Date: 09-Sep-2026
Our Ref: 2026/92299

**Application for a non-material amendment following a grant of planning permission,
Town and Country Planning Act 1990**

**Non material amendment to previous permission 2021/94622 for Reserved Matters
application pursuant to outline permission 2018/60/91787/E for demolition of
existing buildings and structures and erection of residential development
Greenside Mills, Saville Road, Skelmanthorpe, Huddersfield, HD8 9EE
Application Number: 2026/92299**

Page:	Sheet 1 of 1	Drawn:	JM
Ref:	TSE-03083-A	Rev:	B
Date:	04/08/2026		
Scale AS INDICATED

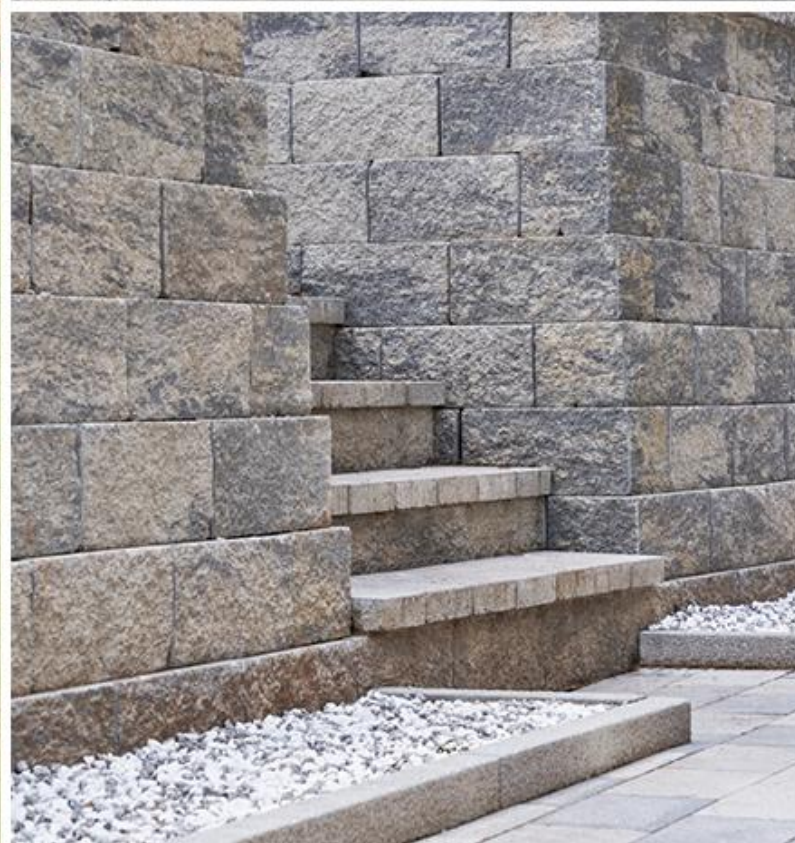
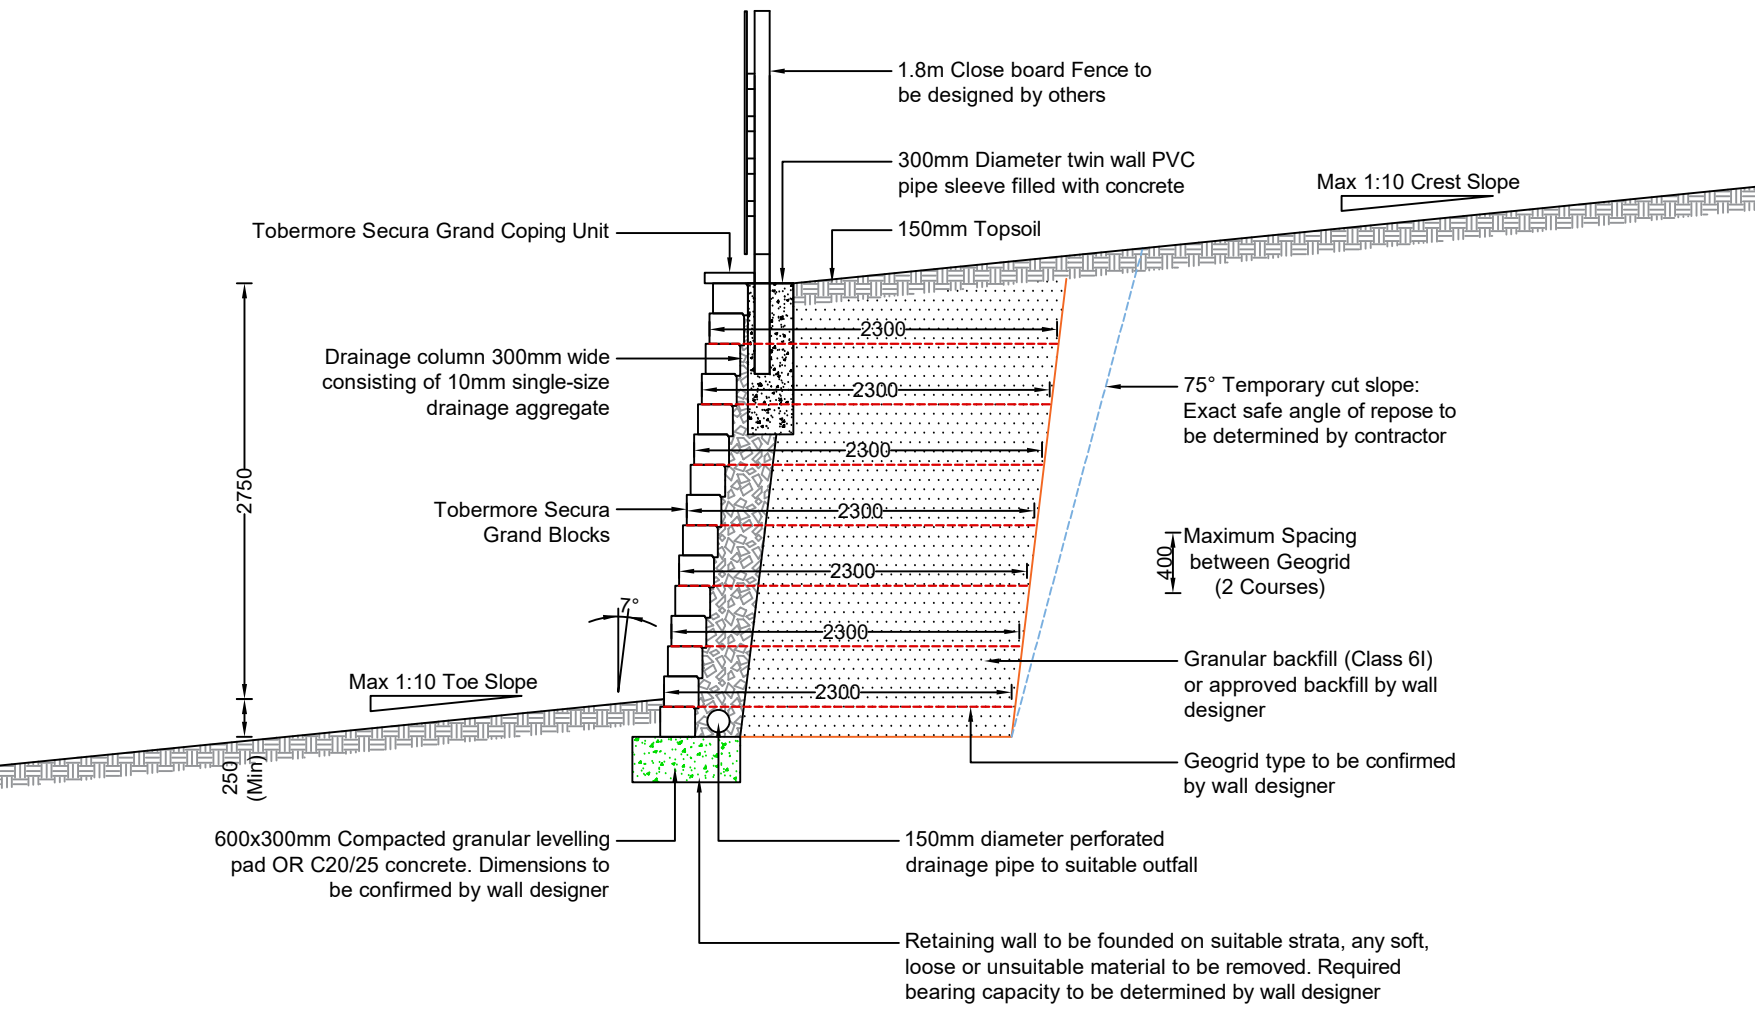
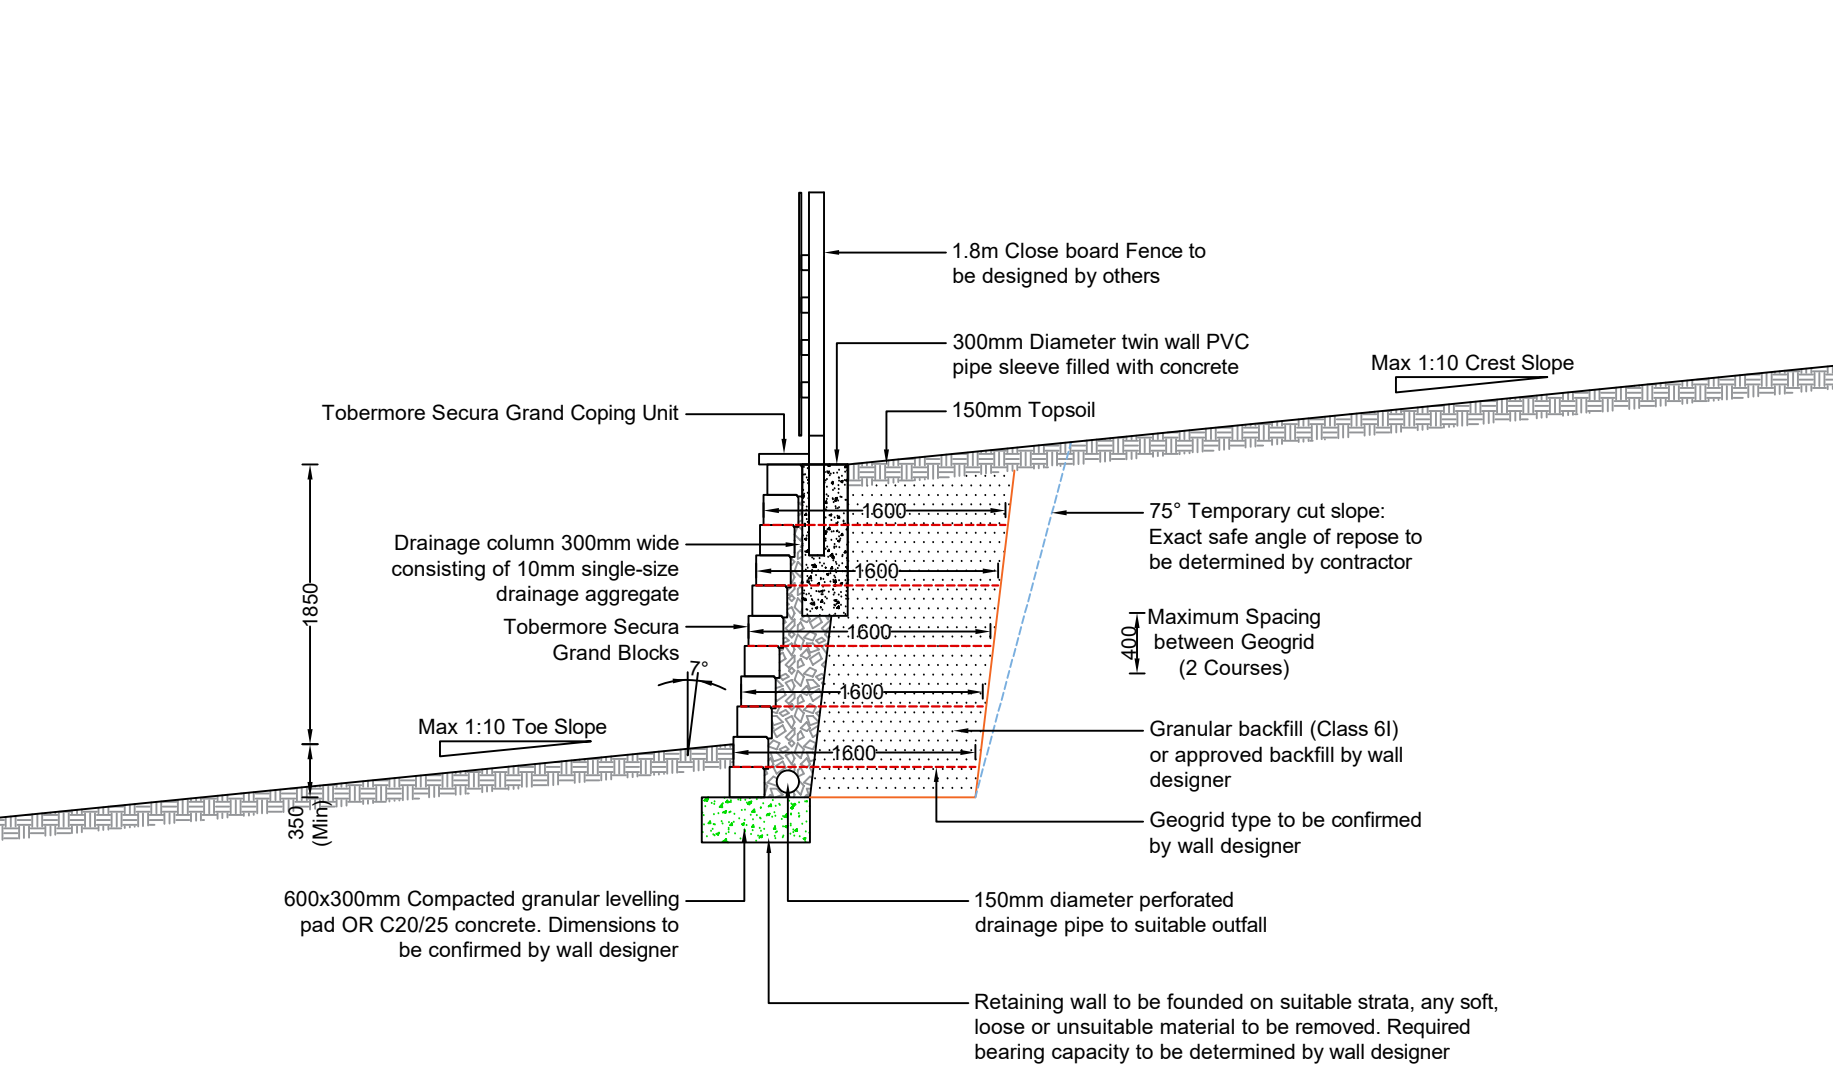
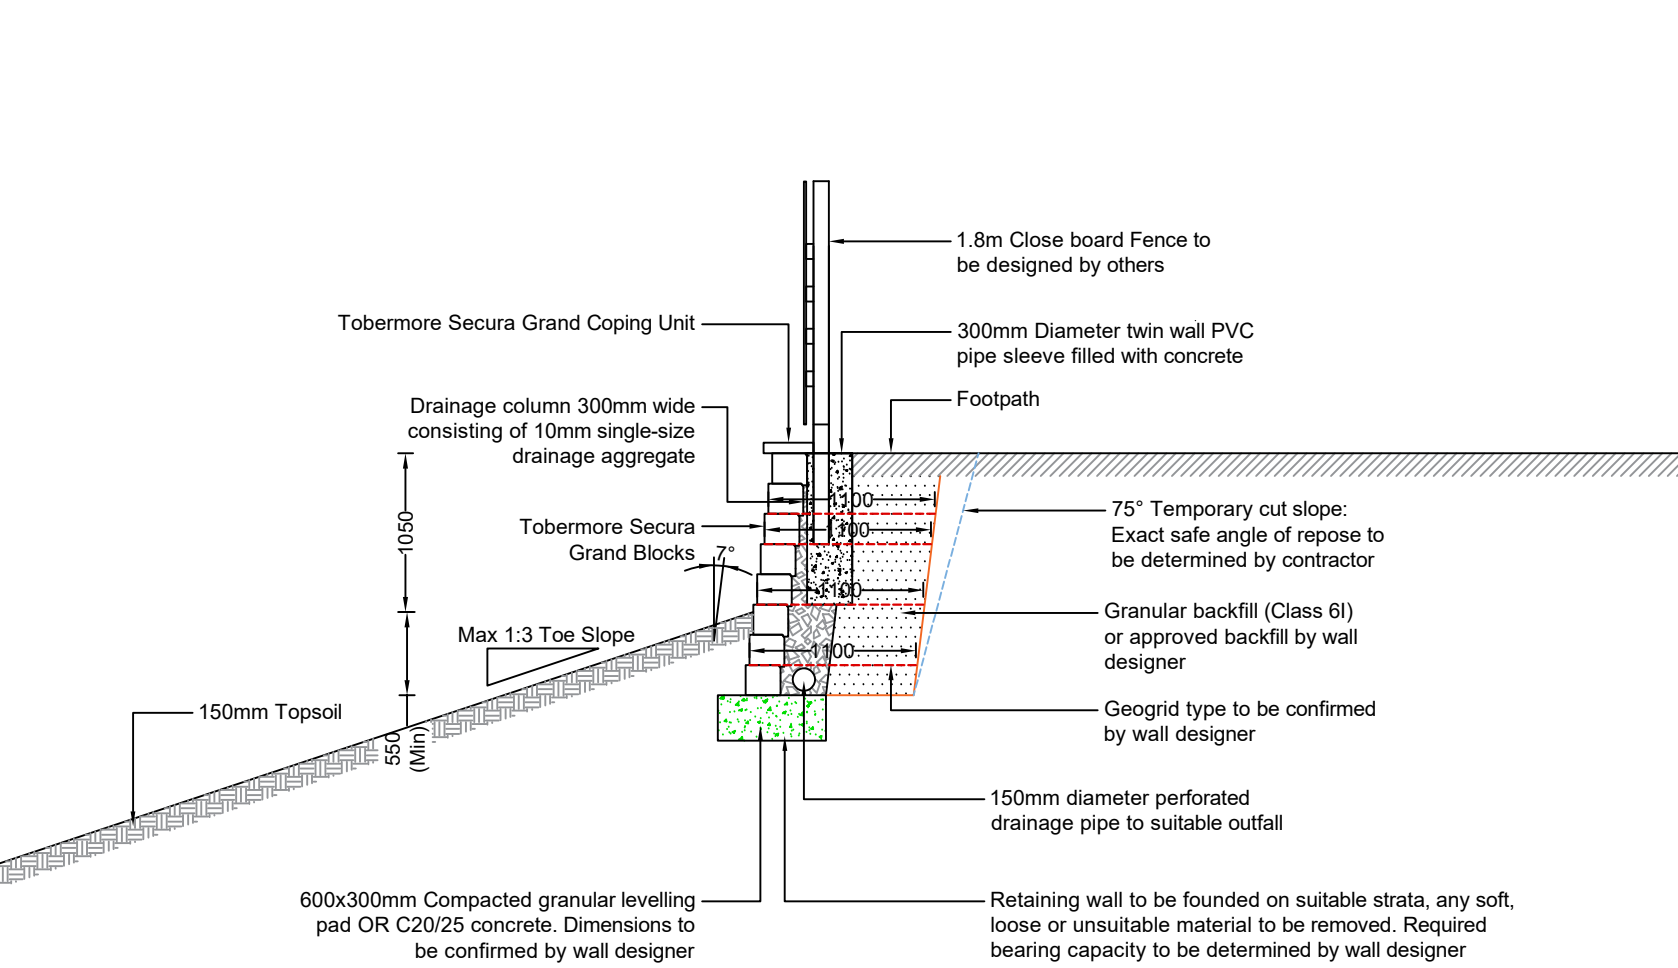
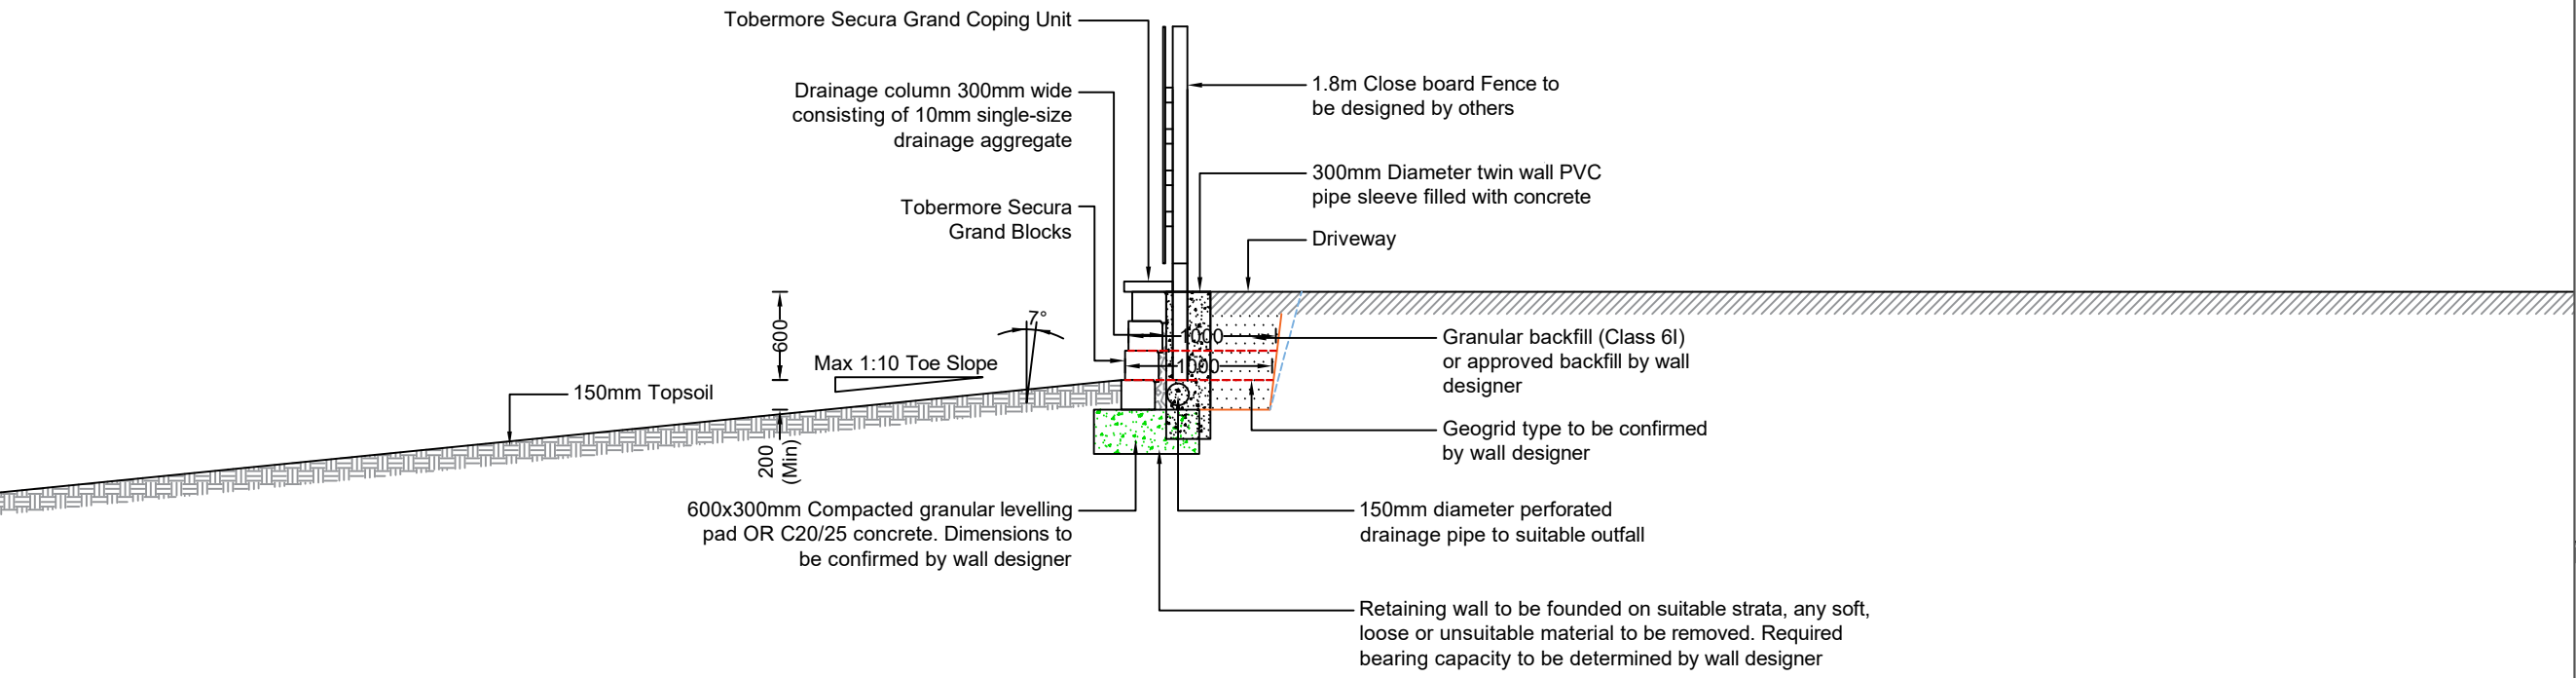
- To amend the construction of the identified retaining walls from walls faced in Cromwell weathered pitch face artificial stone to either a 'Tobermore' interlocking concrete construction, in colour 'Bracken' as shown on the Tobermore Secura Grand webpage (and confirmed via email correspondence from the applicant), or facing concrete walls in the Bracken modules.

I can confirm that the proposed alterations, as outlined above, are acceptable and may be considered as a non-material amendment to the approved drawings. This is subject to the

walls being constructed in Bracken colour. As such, condition 15 is hereby amended to read:

15. The hereby approved dwellings shall be externally faced in 'Cromwell Weathered Pitch Face' artificial stone. In accordance with plan drawing reference 2156.66 Rev A the retaining walls identified by a blue line shall be faced in 'Cromwell Weathered Pitch Face' artificial stone. All other retaining walls shown on plan drawing reference 2156.66 Rev A shall be faced in Tobermore concrete walling: colour 'Bracken' as shown on Tobermore Secura Grand webpage unless otherwise agreed in writing by the Local Planning Authority.
